From: Rob Hill
Sent: 30 November 2021 13:36
To: PATEL Sav; Laura Spriggs
Cc: louise@lmcarchitect.co.uk
Subject: [EXTERNAL] FW: Wardentree Lane, Pinchbeck

From: Rob Hill
Sent: 26 November 2021 15:42
To: Dean Whitehead
Cc: Laura Spriggs [Sav](#) [PATEL](#) <[I](#) [Dean Roberts](#)> **Subject:** Wardentree Lane, Pinchbeck

As further discussions have gone with SHDC, and the introduction of their new refuse collection policy, we have had to add further areas of adoptable roads, as per the attached, with a mix of edge lanes and shared surfaces. All roads/lanes have been tracked for refuse as per the attached tracking plan, and all comply.

Drawing:
Planning Site Layout

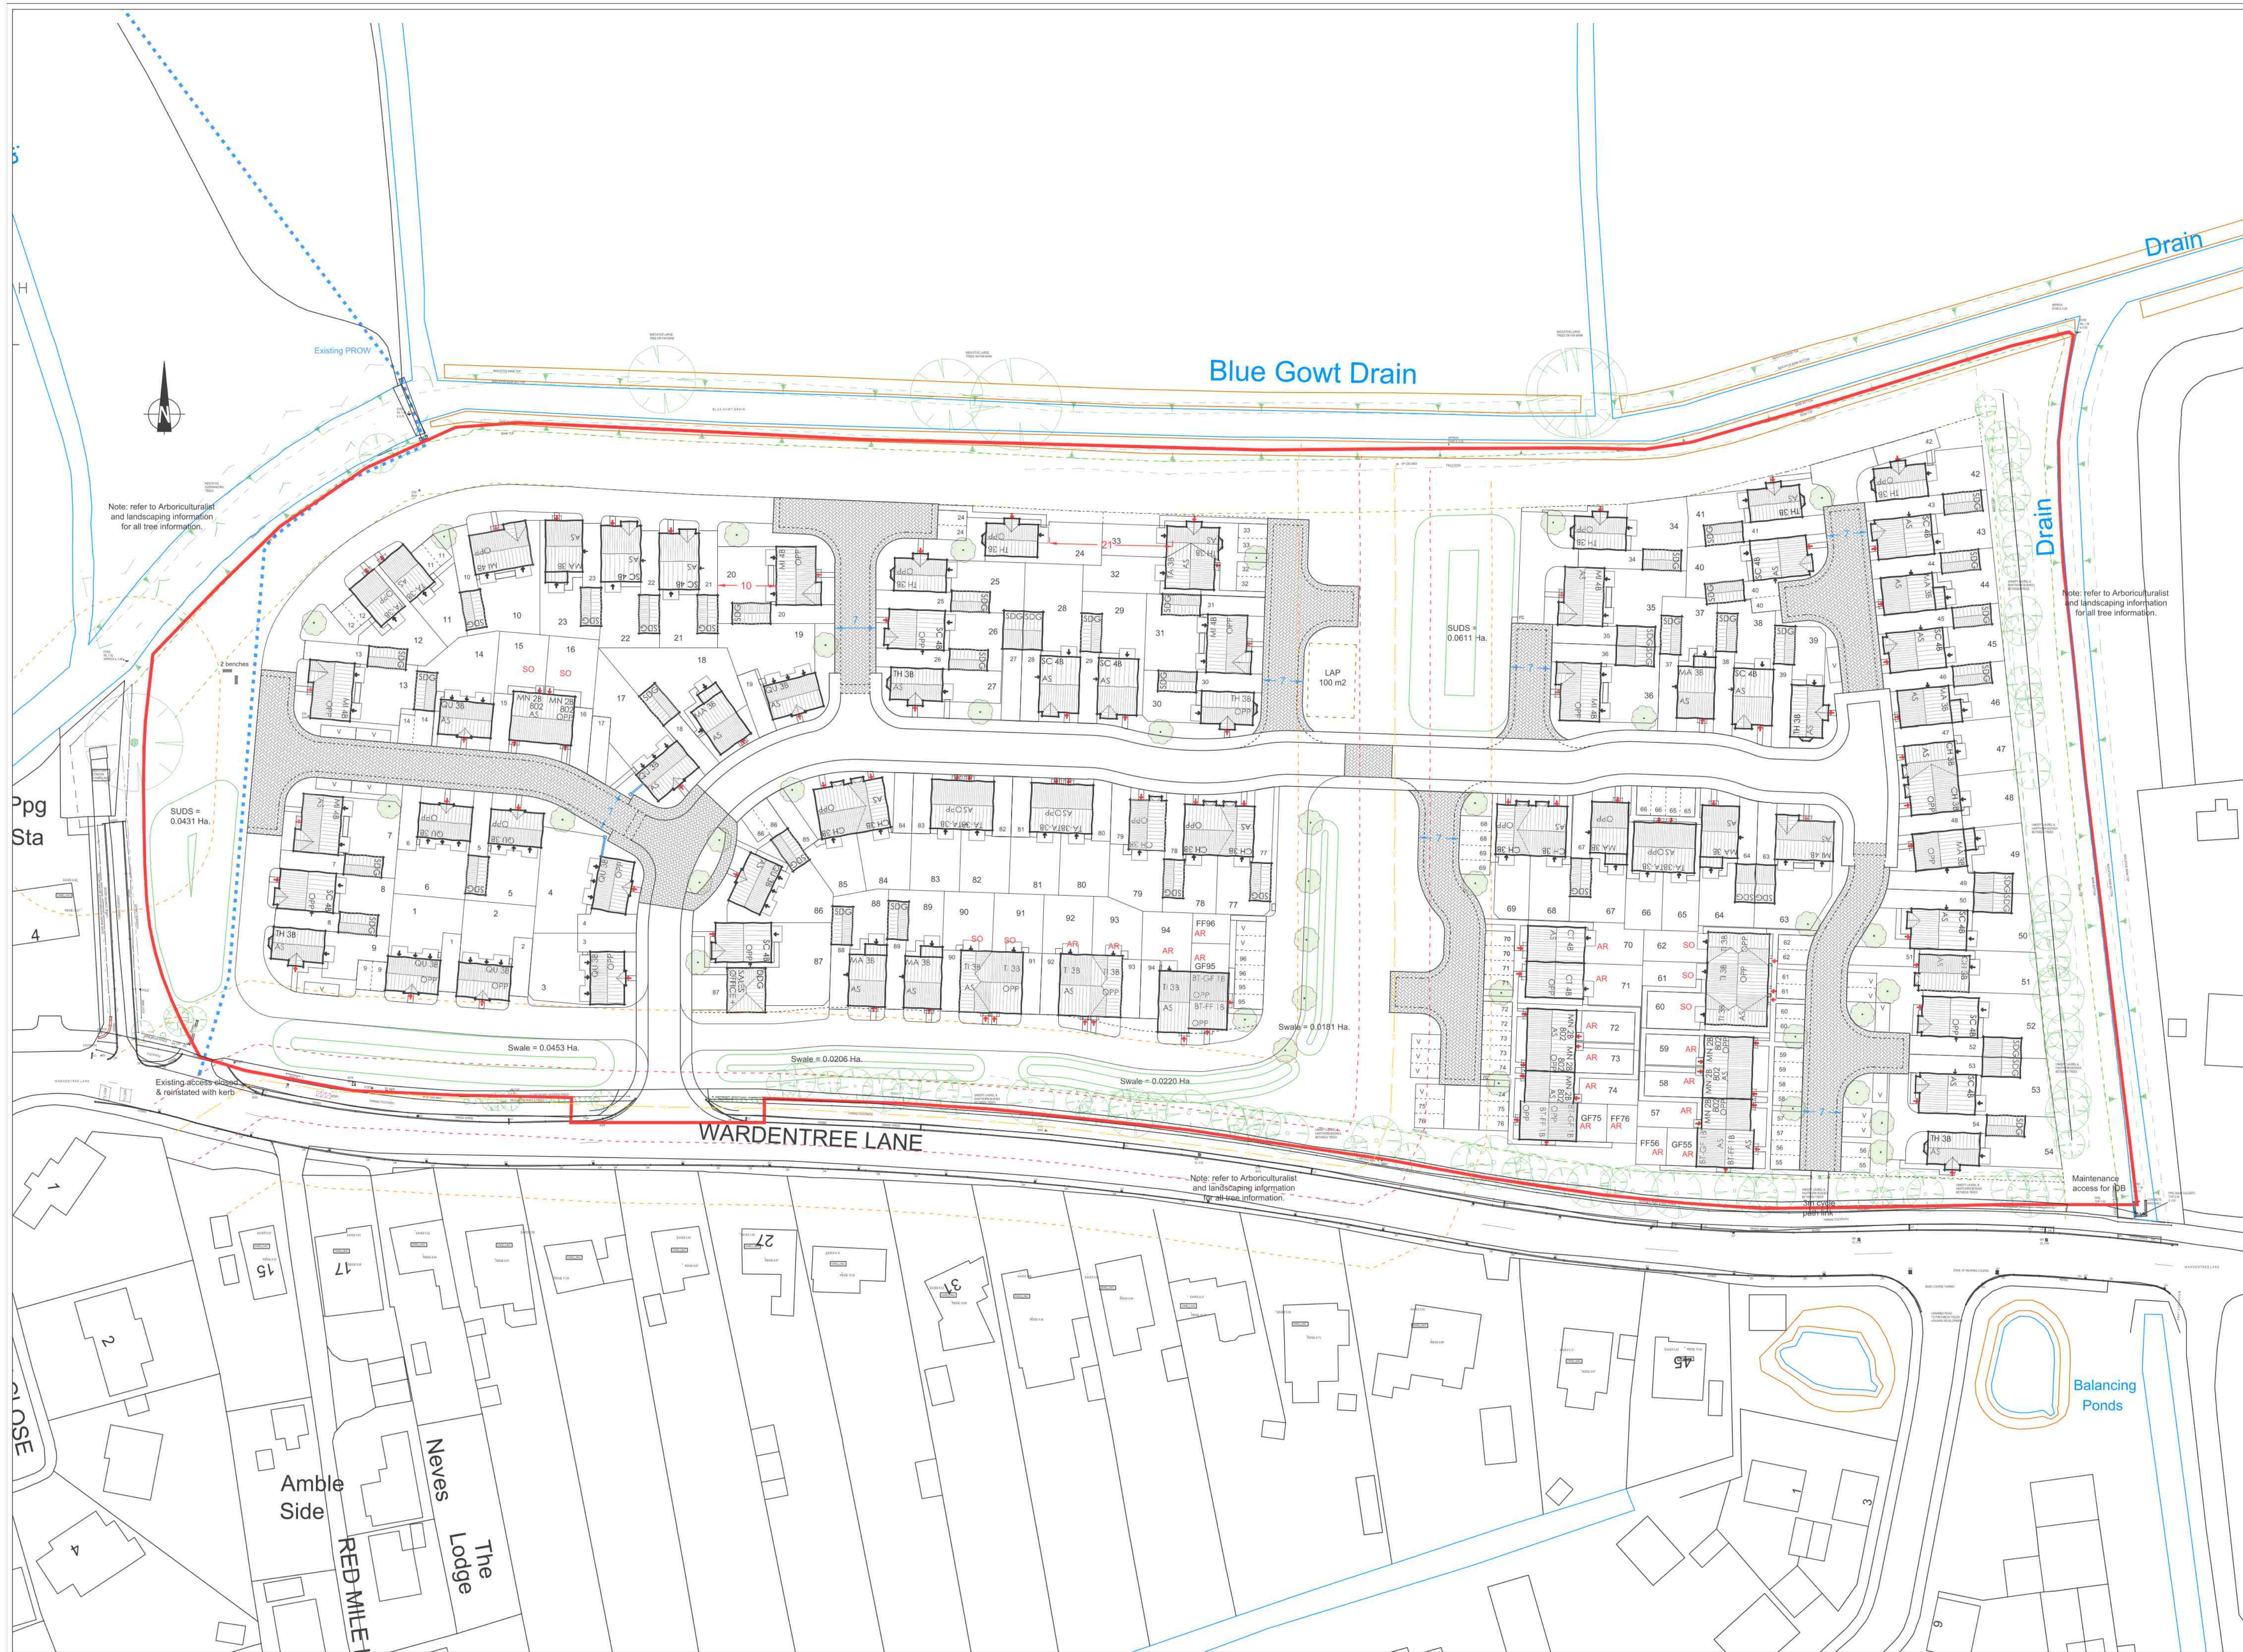
Prior to submission the LPA I wondered if you could confirm that the attached is acceptable to the Highway Authority. I appreciate that the finer detail will be ironed out within the technical approval stage, but I think we have reached a point where every unit has direct access to an adoptable road.

Please be advised that the revised drawing now indicating edge lanes for adoption by this Authority is acceptable in principle, subject to S38 technical approval.
